Planning Application Ref. FP/127/17/PL.
Re. 2 Second Avenue, Felpham.- Proposed two storey dwelling.

I would like to object to the Planning Application for the development of part of the site of 2 Second Avenue, Felpham.. PO22 7LJ.

PROPOSED GROUND FLOOR PLAN

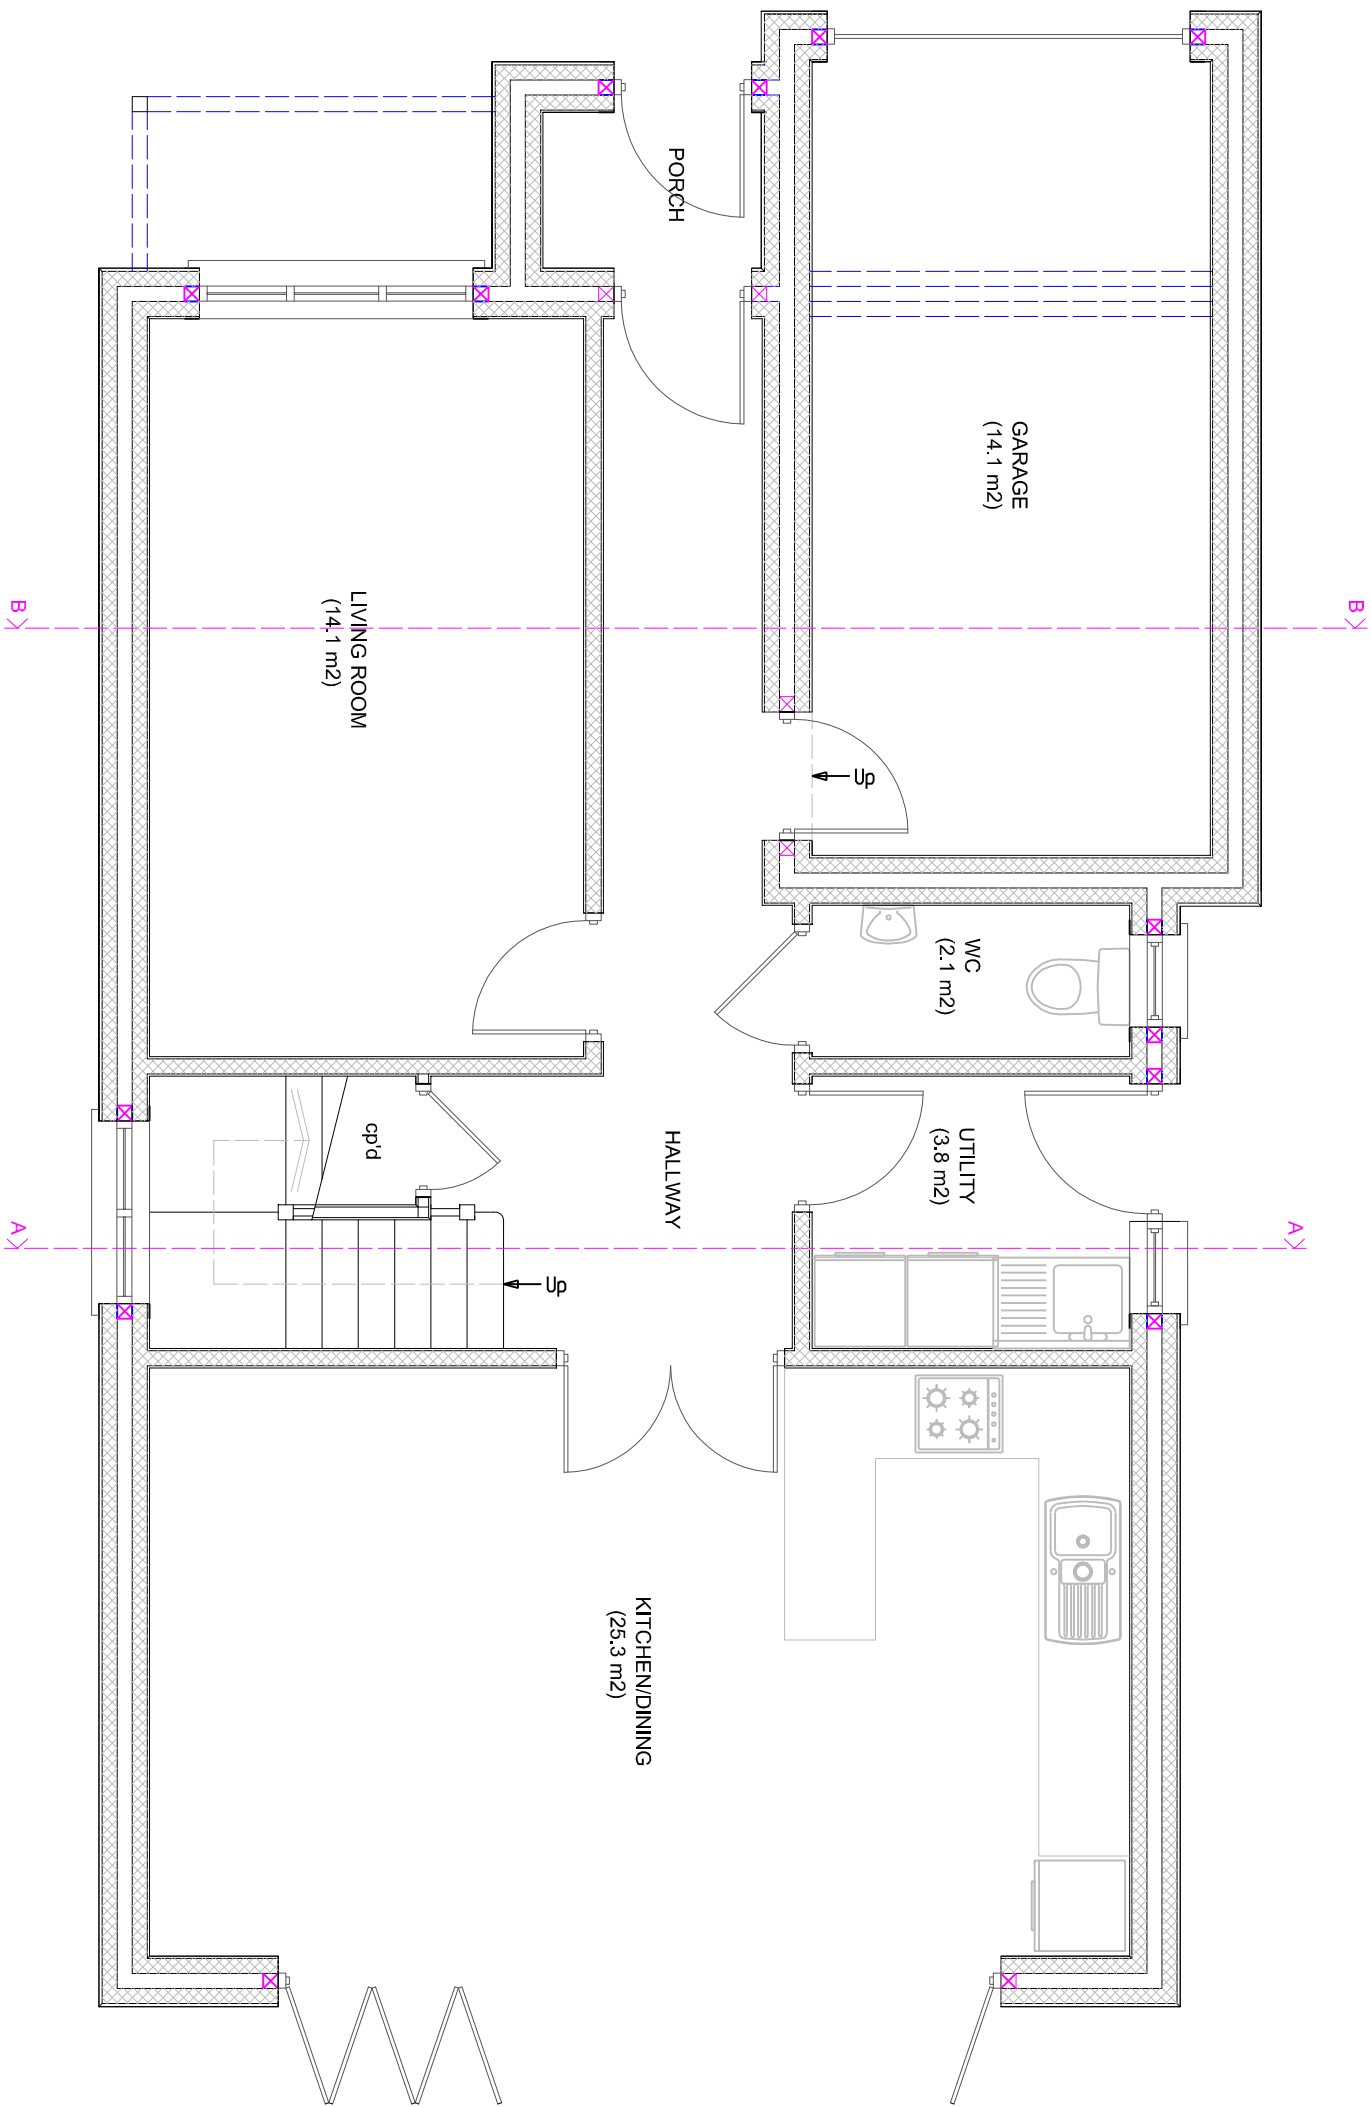
- a) Condition 7. Distances from neighbouring properties. The Plans submitted show a gap of only 2 metres between the Southern elevation of the existing building and the Northern elevation of the proposed dwelling – not the 3 metres required by you. The Southern Elevation of the proposed building is only 1 metre from the fence where the Northern wall of No. 1 Second Avenue exists.
- b) Conditions 3 & 4. Car Parking – Please note that no parking is allowed on the roads at any time. There should be on site parking available for occupants and visitors. The proposed garage door is only just over 2 metres wide, only suitable for a rather small car. It is unlikely to be used continually as part of the on site parking availability.

PROPOSED STREET ELEVATION

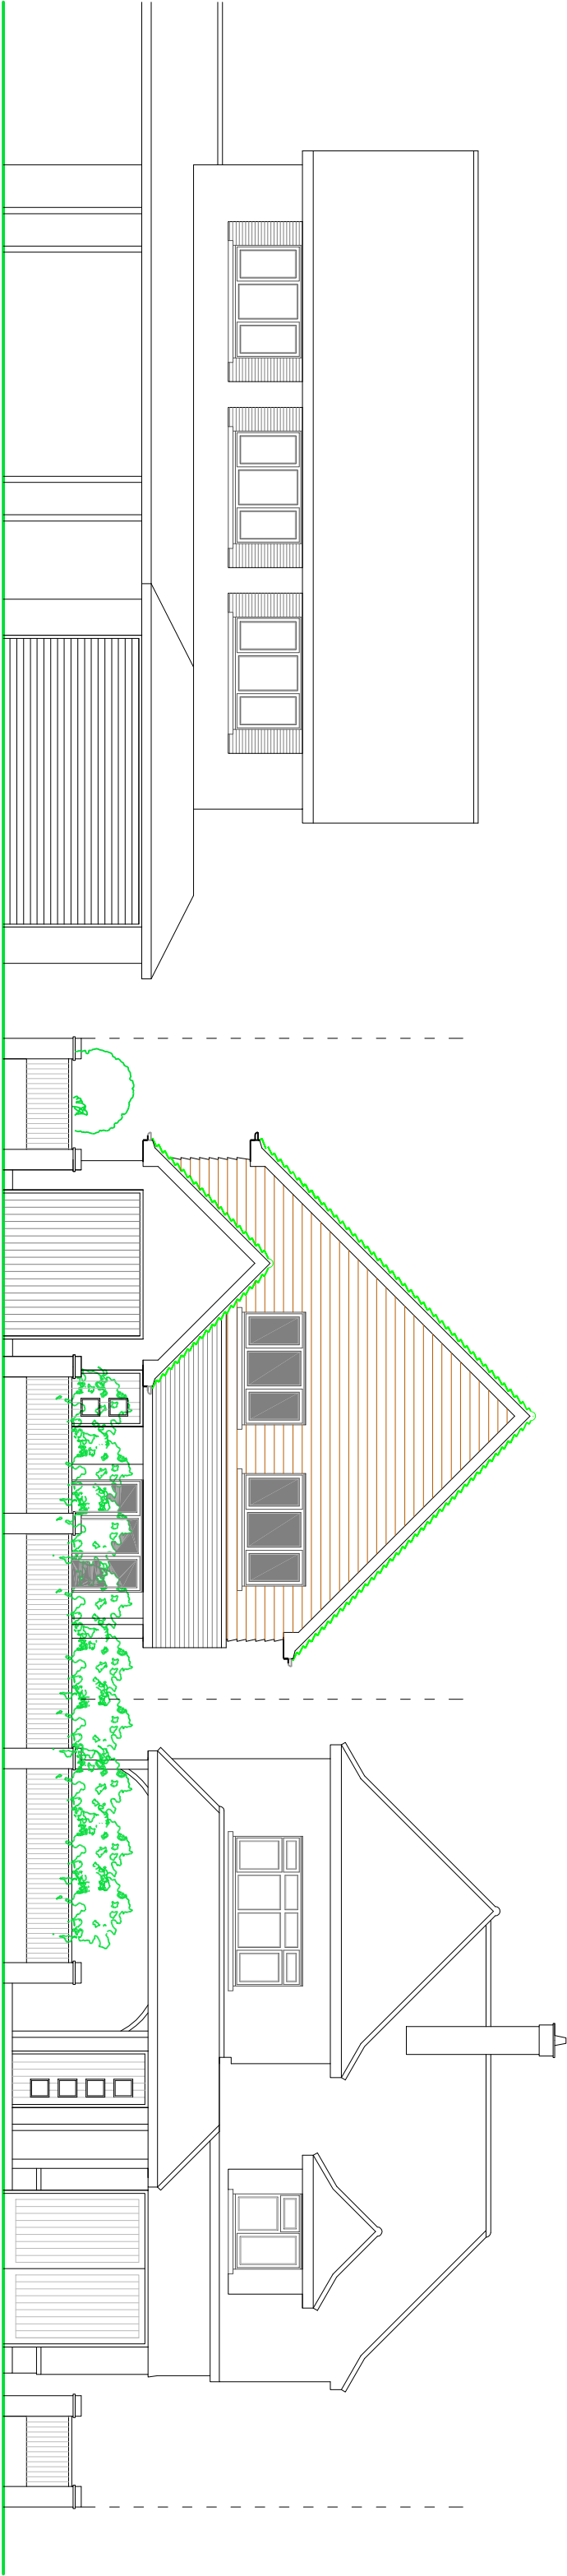
- c) It would appear from the plans that the proposed dwelling is slightly in front of the building line of the west side of the road.
